RE: CHILI'S RESTAURANT @ LA CUEVA TOWN CENTER (C-19/D11D5)ENGINEERS CERTIFICATION FOR CERTIFICATE OF OCCUPANCY

ENGINEERS CERTIFICATION DATED 8/30/2001

Re: Chili's @ La Cueva Town Center Drainage Report Engineer's Stamp dated 11-7-00 (C19/D11D5)

ROUGH GRADING APPROVAL		DATE
ENGINEER'S SEAL		
CHILI'S #704 LA CUEVA TOWN CENTER CONCEPTUAL GRADING PLAN		DRAWN BY BDC
		DATE 11-03-00
		2069GR.DWG
		SHEET #
		5
		JOB #
		20003620069

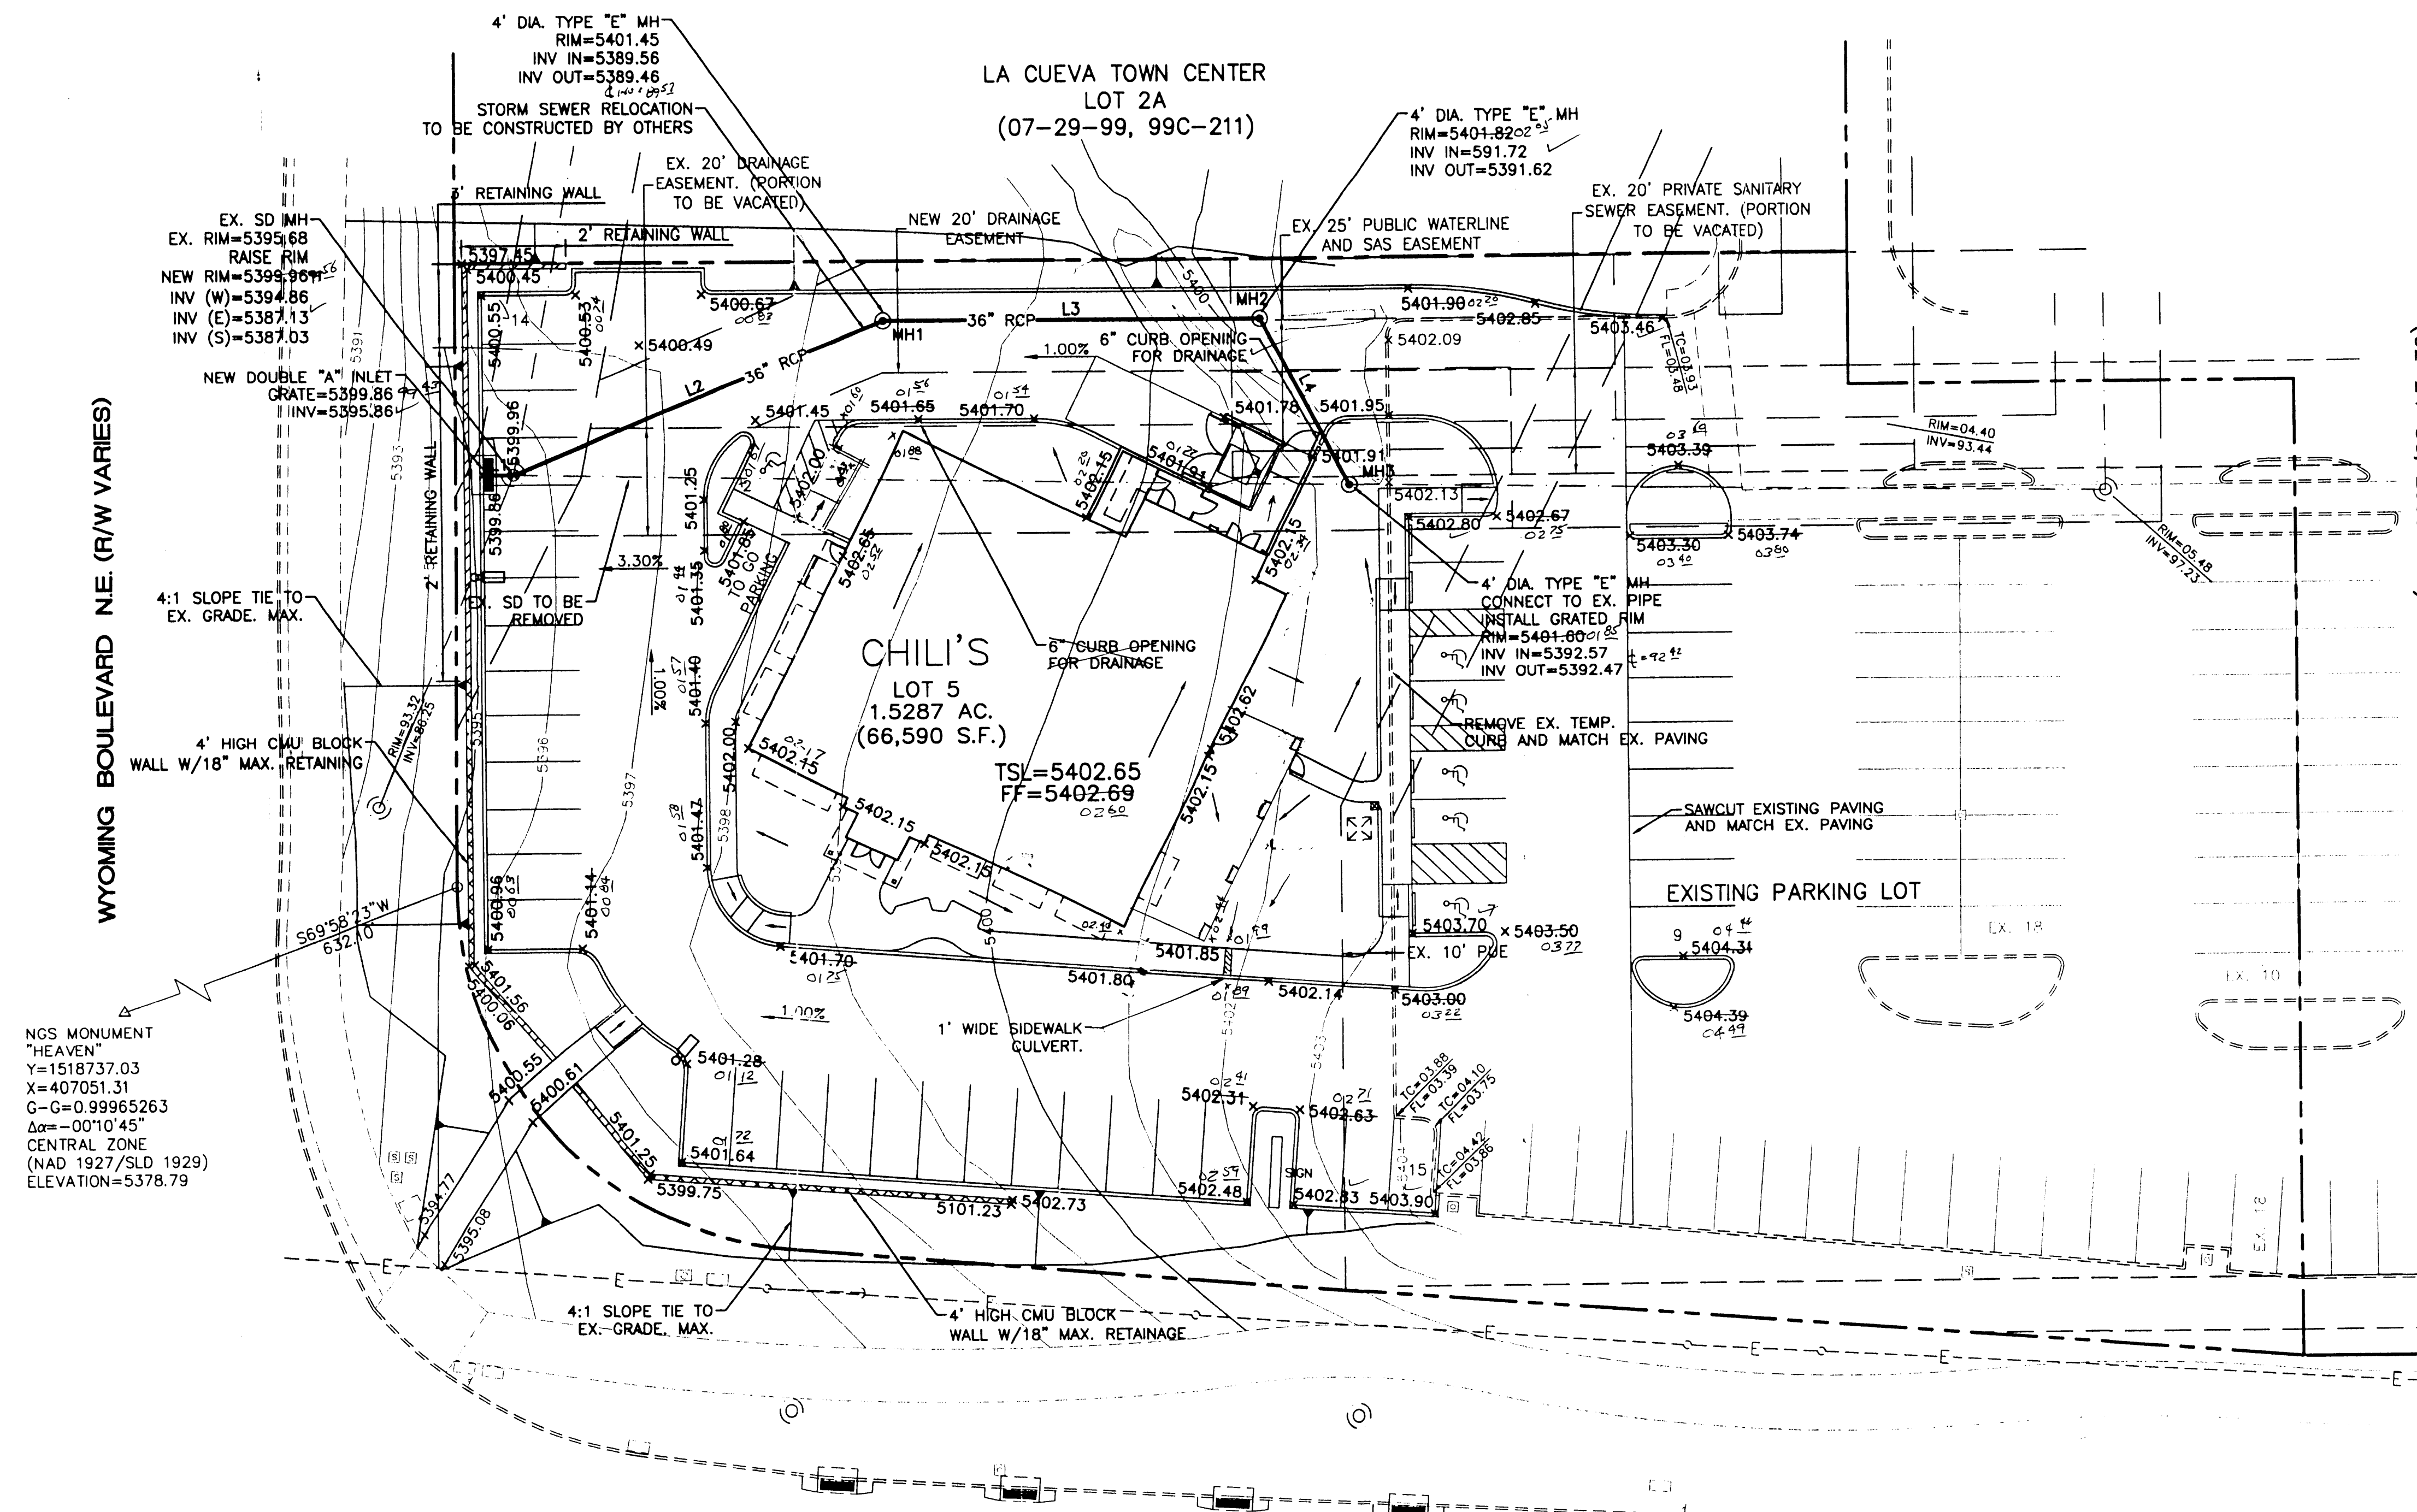
- The grated rim called out for MH3 is not detailed. What is the capacity of a grated rim? What is the runoff impacting this area? Callet $+ y \rho$
- Is the drainage easement public or private? If public, a Work Order will be required.
- It appears that some of Basin A is surface draining to your site, not completely in the pipe as stated. Please provide an updated offsite basin map and reanalyze the inlet.
